**WEST SUSSEX COUNTY COUNCIL
STRATEGIC PLANNING CONSULTATION**

**SUBJECT: LU/275/12/DOC - Application for approval of details reserved by Condition 5
(proposed access arrangements) following grant of planning permission LU/105/11.**

**Charnocks Garage Site, Beconsfield Road, Littlehampton, West Sussex, BN17
6LN**

drawing
Ground Floor / Site Plan

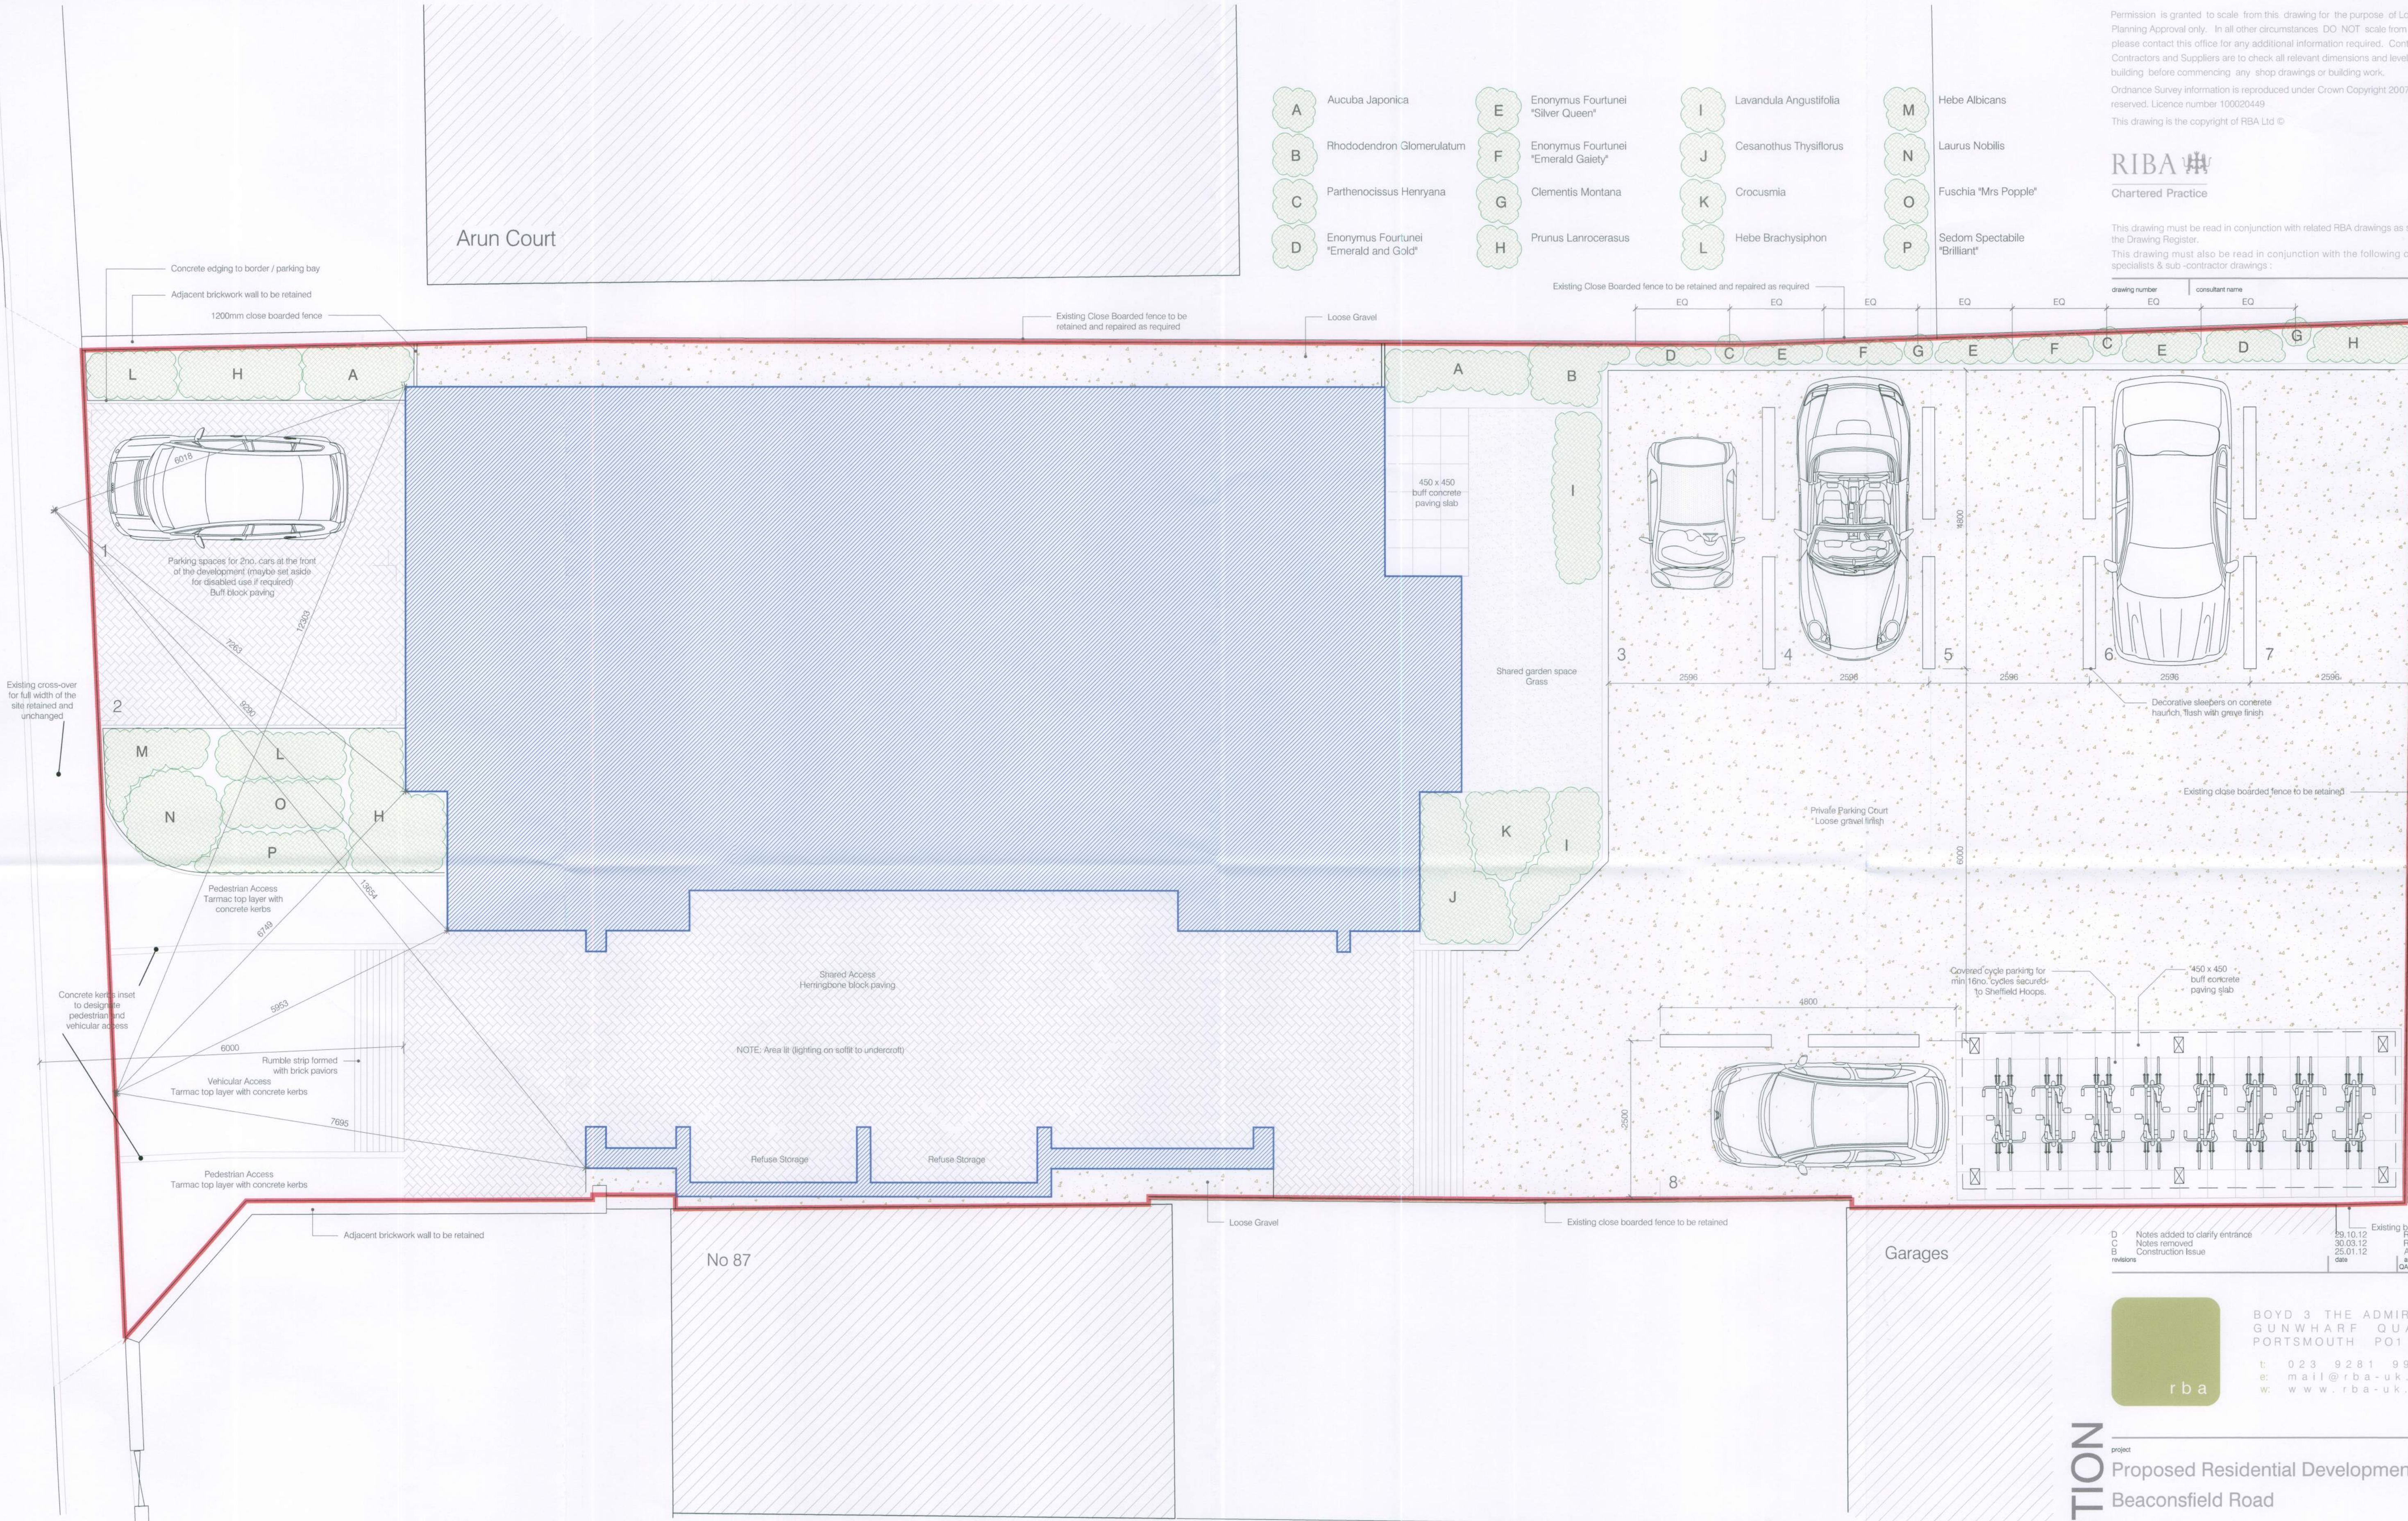
As parking has historically occurred to the front of the property there is an existing dropped kerb running across the entire frontage of the site.

It is proposed for 2 parking spaces, a vehicular access to the rear and pedestrian walkways to be contained within the site. No changes are proposed to the highway for these works.

As no changes are proposed to the highway we would not object to the discharge of Condition 5.
